**Consultation Response from KC,
Trees**
2021/93644 Low Farm, Wakefield Road, Flockton, Huddersfield, WF4 4BB
Erection and operation of grid-connected solar photovoltaic farm, with ancillary infrastructure and landscaping and biodiversity enhancements
Date Responded: 05/11/21
**Responding Officer: Nick
Goddard**
Responding Ref: TPO KB1/49

Figure 4.2 Proposed Site Access Points

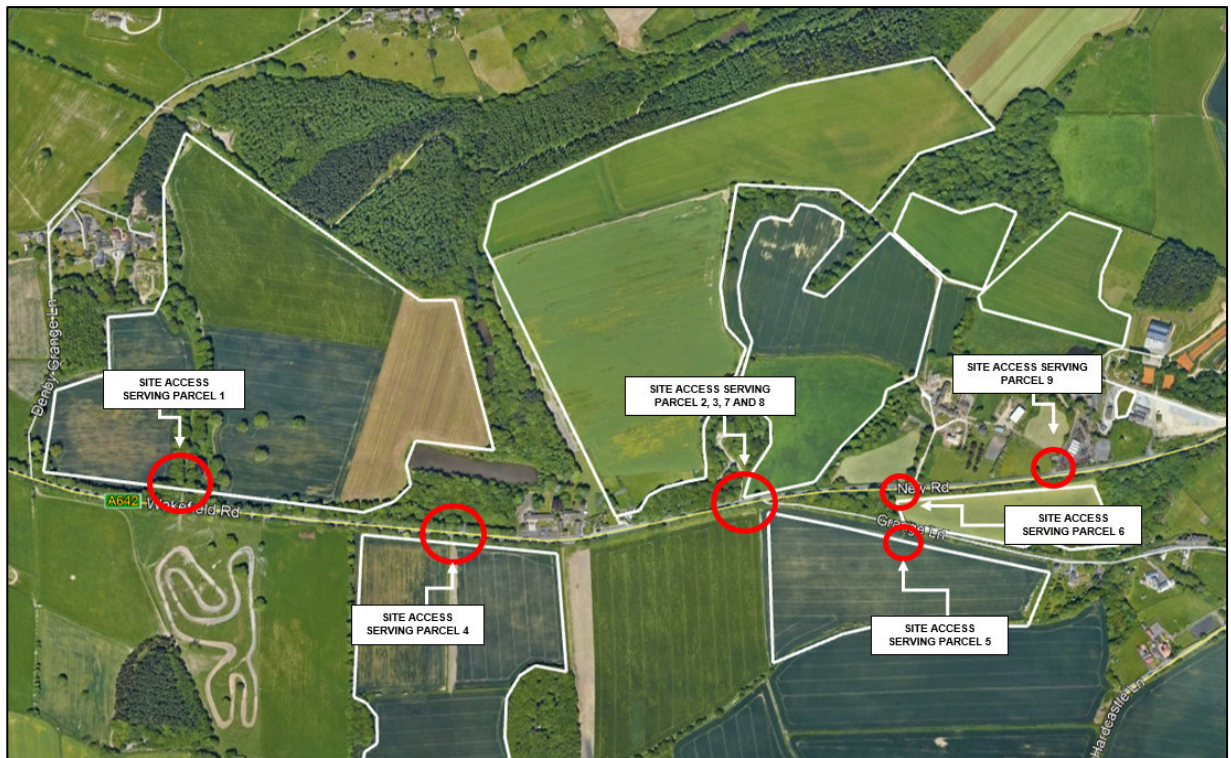
The site's access from Wakefield Road is to use an existing gateway that leads to a track that runs down the centre of a woodland, comprising of an avenue of mature trees with established woodland on either side. The proposed access would then turn off right to the compound or left to the adjacent field at the western end of the site.

The access does not appear to have utilised an existing gap to reach the compound and the proposals would therefore impact on this protected woodland. This would be clearer had an AIA been submitted with the proposals. There is some potential for the access to be made through the woodland but it should be designed in such a way to avoid unnecessary removal or harm to the main components of the woodland.

The access to the western field is similar but then also heads north along the outer edge of the woodland instead of being positioned far enough out into the field as to avoid impacts to the adjacent trees.

Access to area 4 from Wakefield Road is positioned close to a significant tree and does not utilise an existing gap further west. This could result in damage to the tree's roots, leading to decline and early decline. It is hoped that existing gaps in tree cover could be utilised to avoid such impacts.

Access to area 5 from Grange Lane will require the removal of at least one tree however the tree was of poor quality and should not be a constraint on the proposals.

Figure 4.3: Indicative Construction Compound

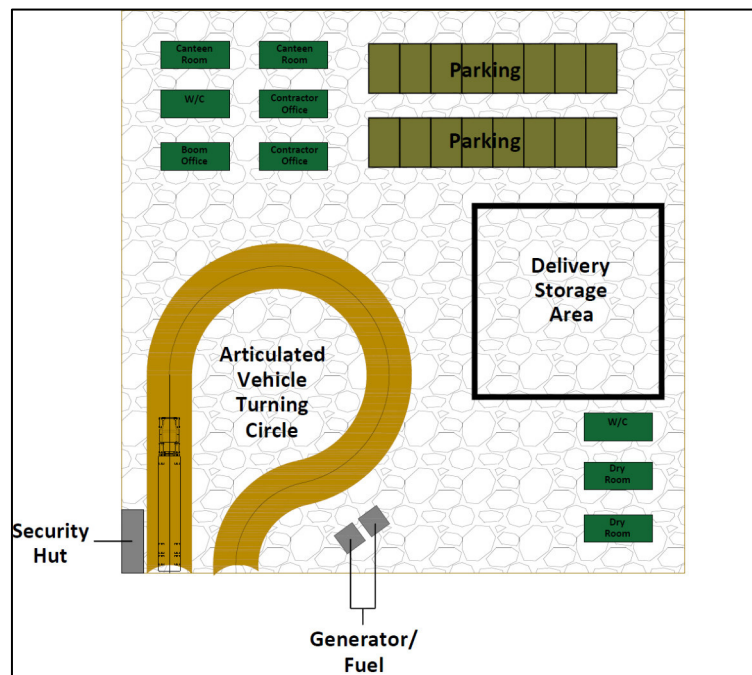
The compound location and details of its layout have been provided and would conflict severely with the adjacent trees along Wakefield Road. The mature trees along Wakefield Road could be avoided by moving the compound further into the site, again this would have been clearer had an AIA been submitted with the proposals.

Figure 5.3 Internal Access Track Cross Section

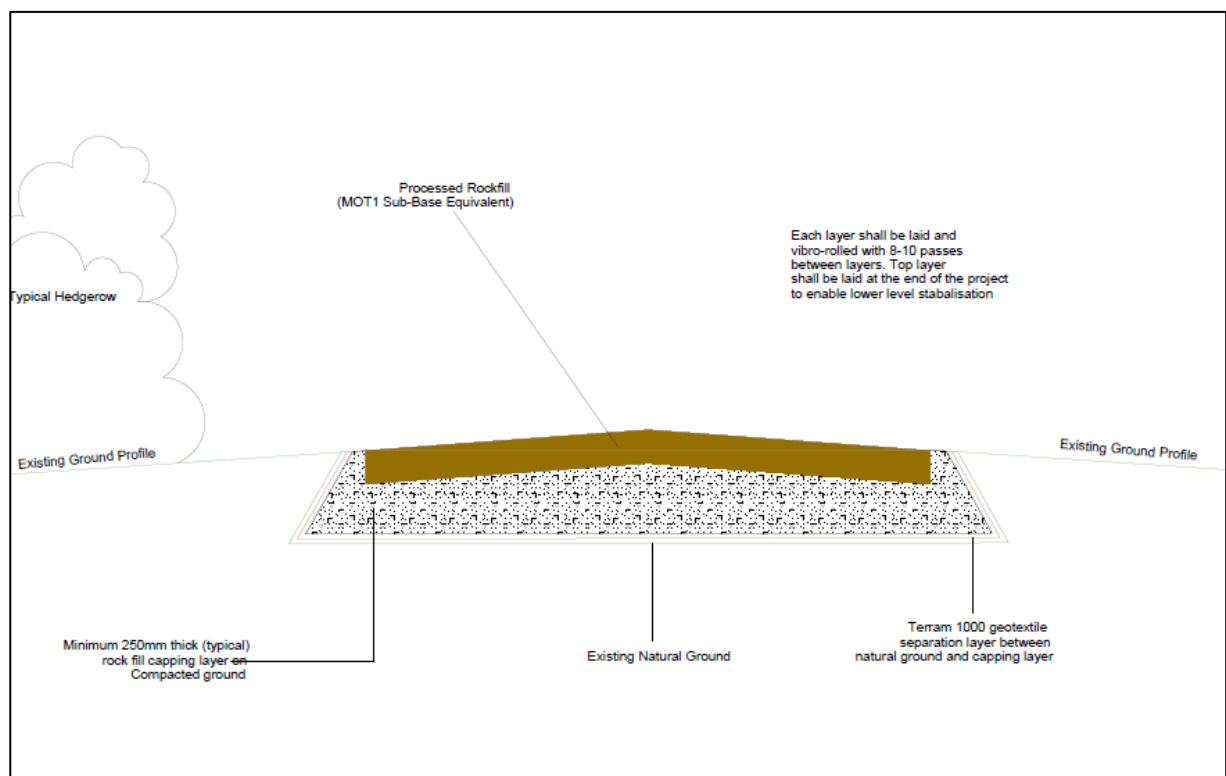
The access tracks around the site are to be constructed to a specification of approximately 4m wide and 0.5m deep according to the Internal Access Track Cross Section drawing. The majority of tree roots exist in the top 0.6m of soil so excavation as proposed will be harmful where it is in close proximity to trees. In much of the site where the track crosses existing fields this proposal causes no issues with the existing tree stock, however in places this construction will result in conflict with trees which has been summarised below.
